Mr Brett Hawkins  
Chief Executive Officer  
The Trustee for Greenspot Wallerawang Unit Trust  
2 Wella Way  
Somersby NSW 2250

15/03/2022

**Wallerawang Battery Energy Storage System (SSD-14540514)  
Request for Additional Information**

APPENDIX B SITE POST-DEVELOPMENT LAYOUT

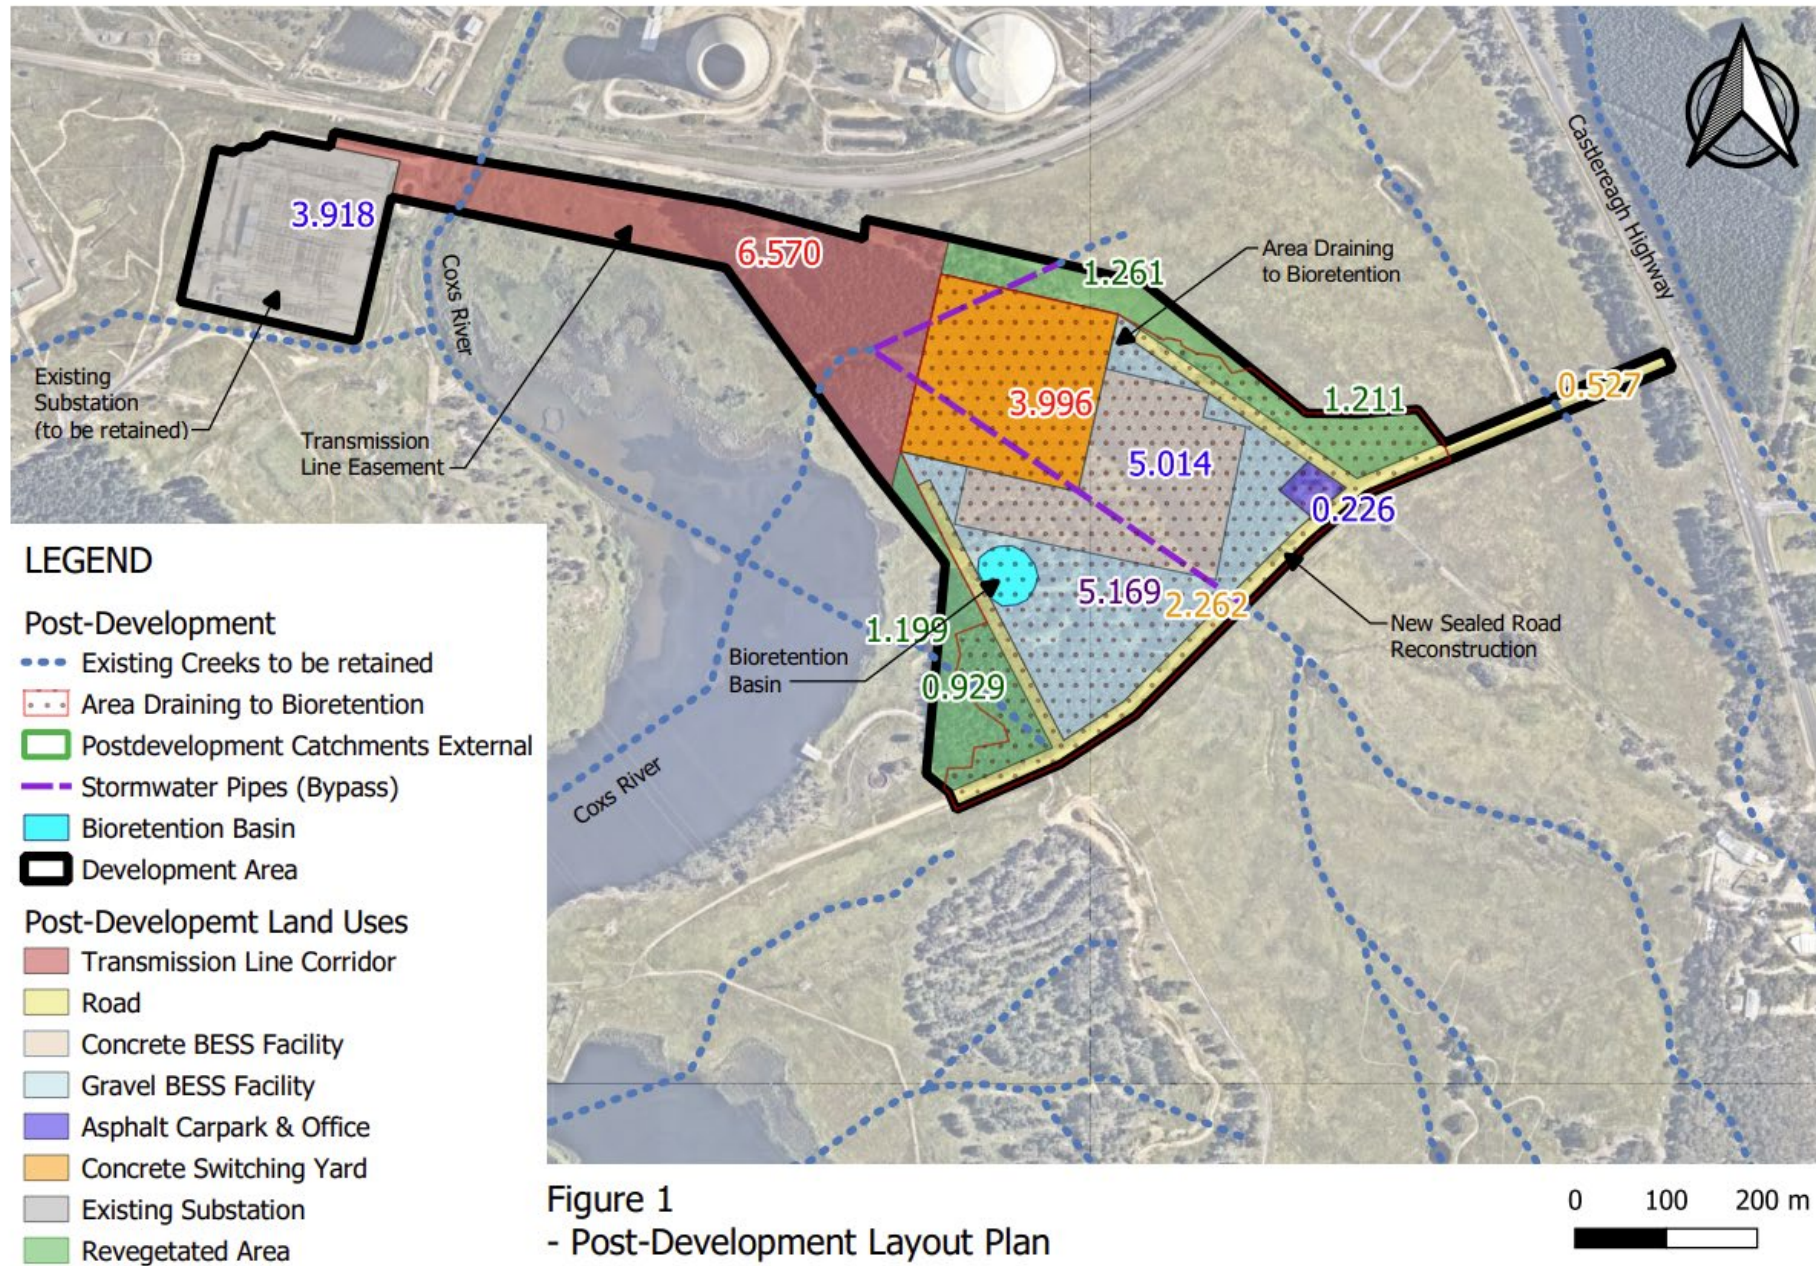
- ensure all site layout plans are consistent, including the EIS site layout plan, the indicative battery layout plan in the Noise and Vibration Assessment and the post-development layout plan in Appendix B of the Water Quality Assessment;
